City of Albuquerque Stormwater Construction Site Inspection Report

ESC File No.	M10E020	Project Name:	Kidz Academy and The Human Bean		
NPDES Id. No.	NMR1003NO/NMR1003NP	Location:	7800 Sage Rd. SW		
7/6/2021	Owner	Contractor			
Operator	Kidz Academy Preschool Lader Real Estate, LLC	Creative Design Builders			
Contact name & title	Keith Griego	Raymond Herrera			
e-mail	kidzacademystaff@gmail.com	rhcdb46@yahoo.com			
Contact Phone #	505-681-7812	505-410-9020			
COA Inspector	Thomas Evans	Start/End Time:	2:20 PM-2:30 PM		
Construction Phase:	Vertical				
Type of Inspection:	Regular	Storm Event	Past Storm Event >0.25"	311/Complaint	Follow Up
Weather at time of inspection?	clear	Temperature:	~ 91		
Estimated date of last storm 0.25" or greater	7/6/2021

TEMPORARY EROSION AND SEDIMENT CONTROL PLAN

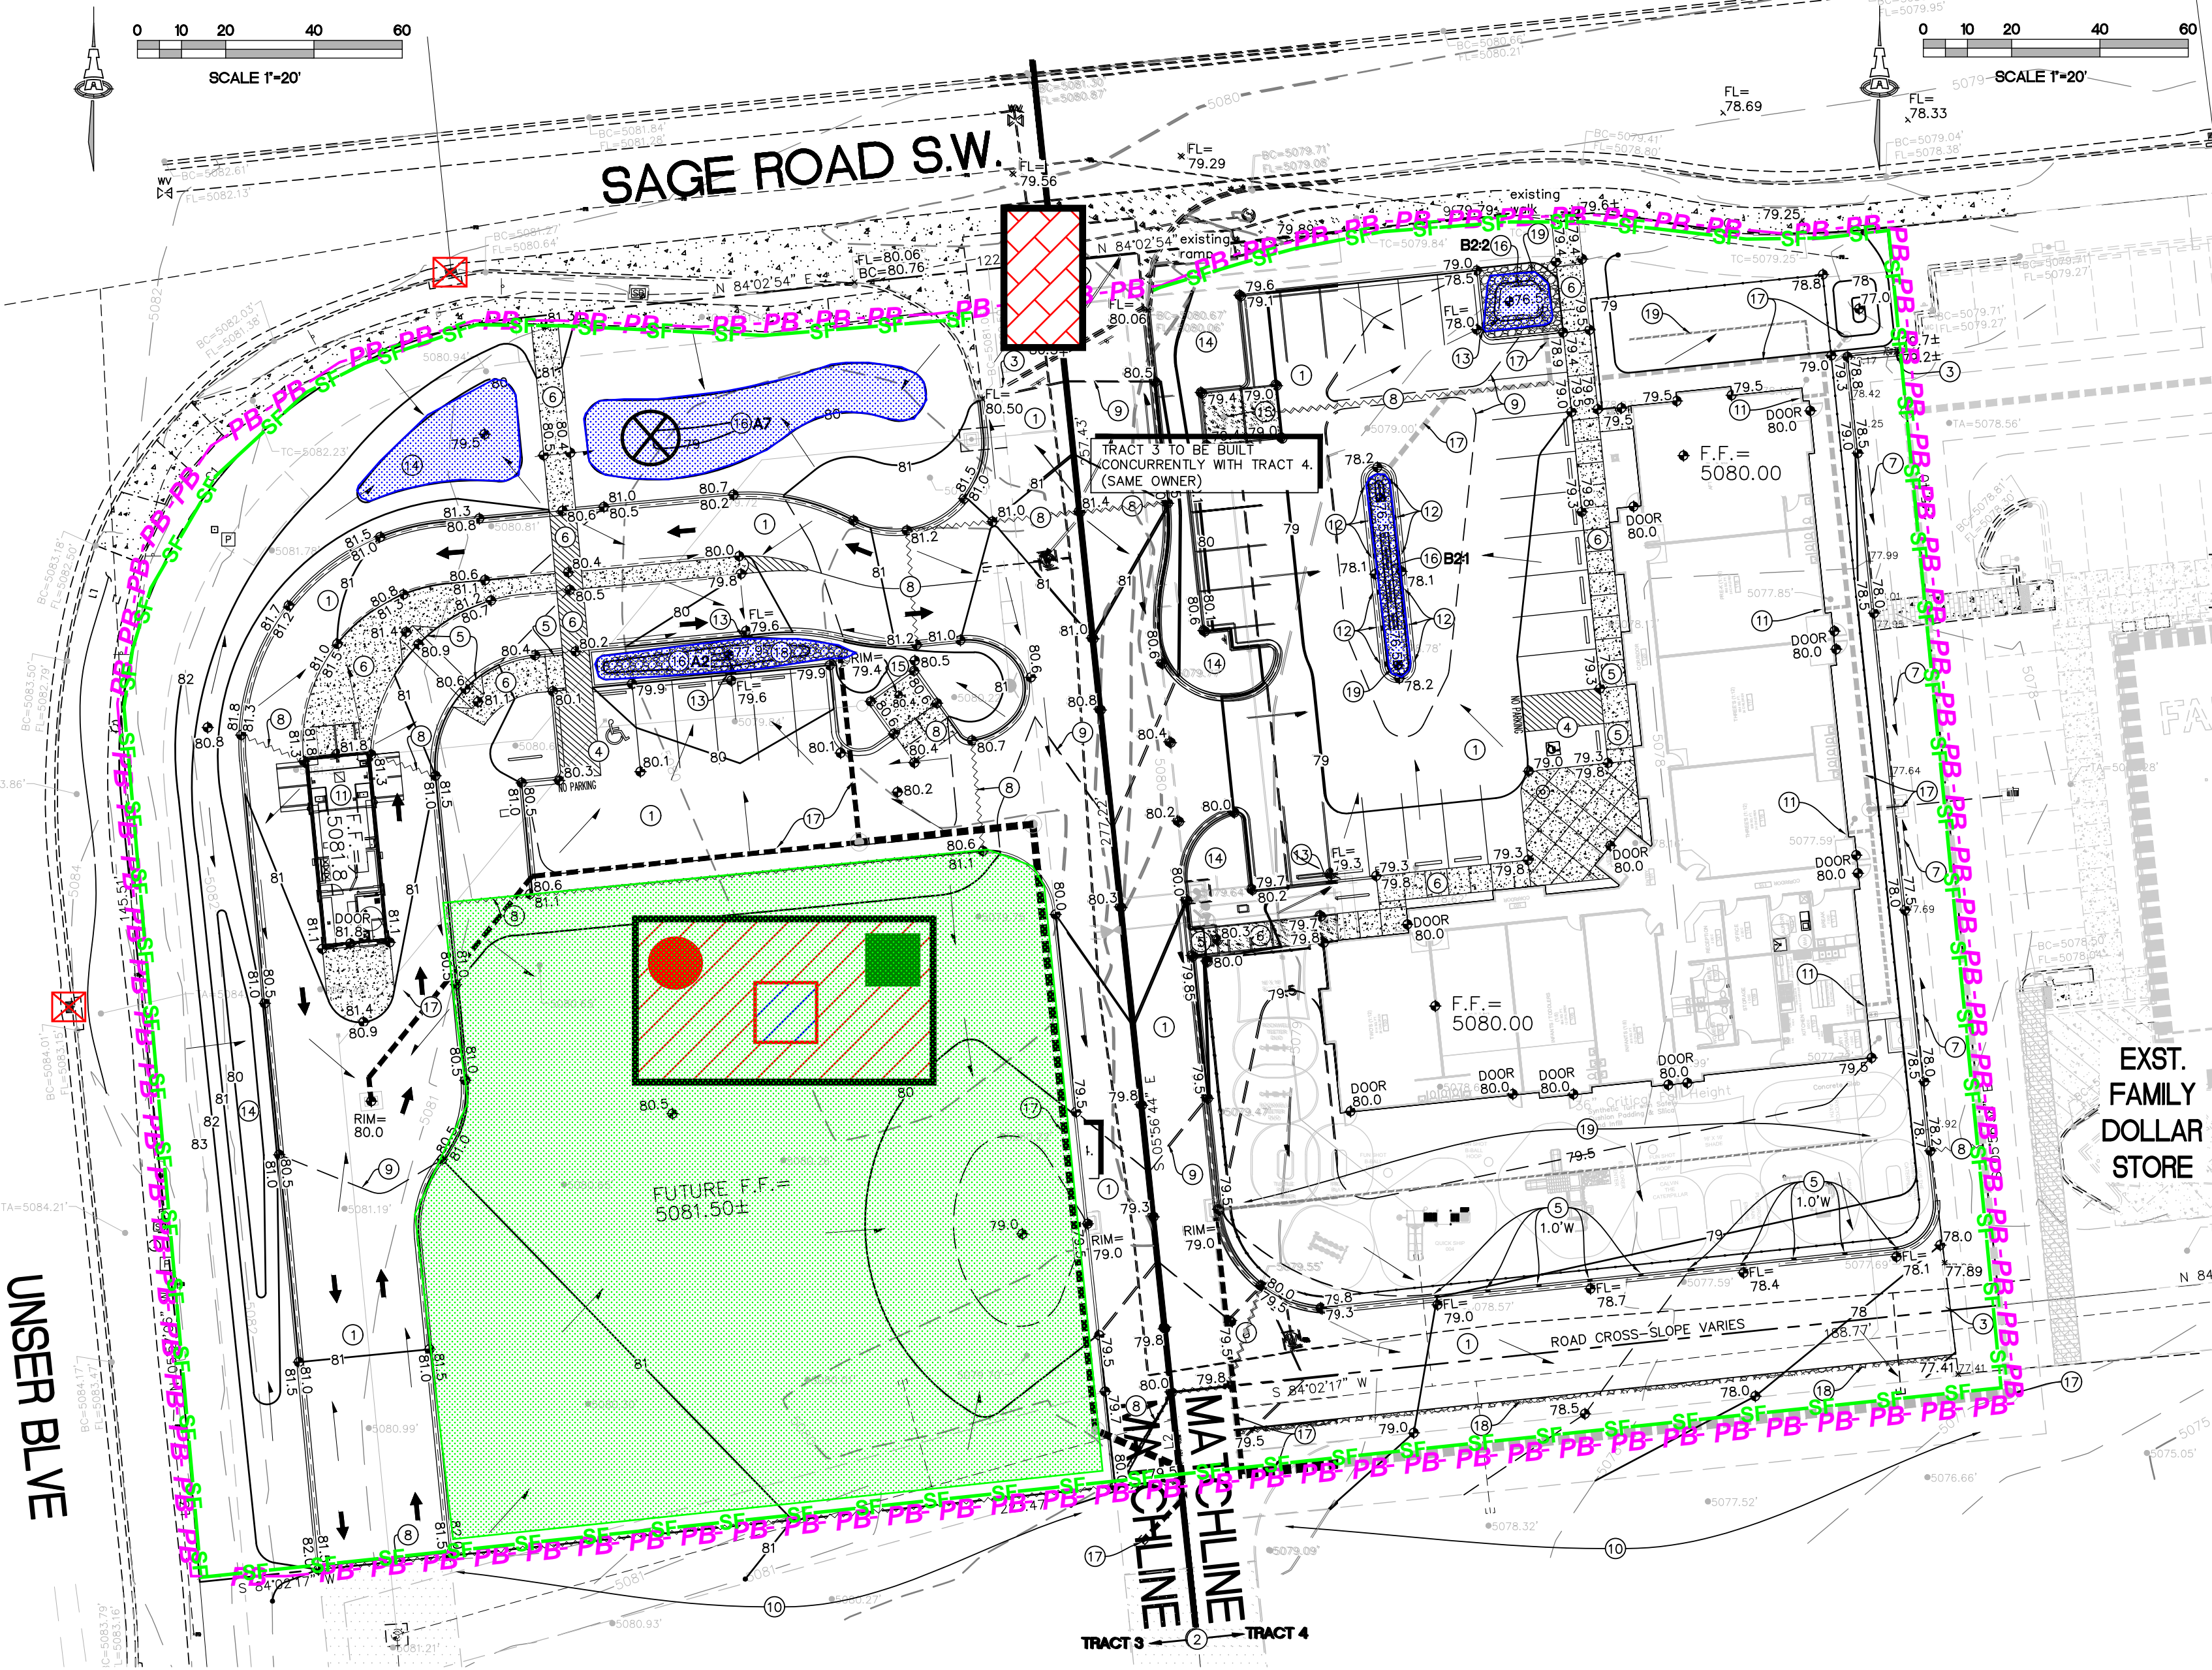
Item Number	Deficiency/ Corrective Action				
1	Construction/domestic waste on ground. Place construction/domestic waste in an approved waste container.				
2	Sediment in street/parking lot. Remove sediment from the street/parking lot daily.				
3	Silt fence down on East fence line. Repair/maintain silt fence.				
4	Sediment accumulation at inlet. Remove sediment from wattles and maintain inlet protection.				
5	SWPPP was not on site. Keep SWPPP on site and readily accessible. Keep self-inspection reports in the
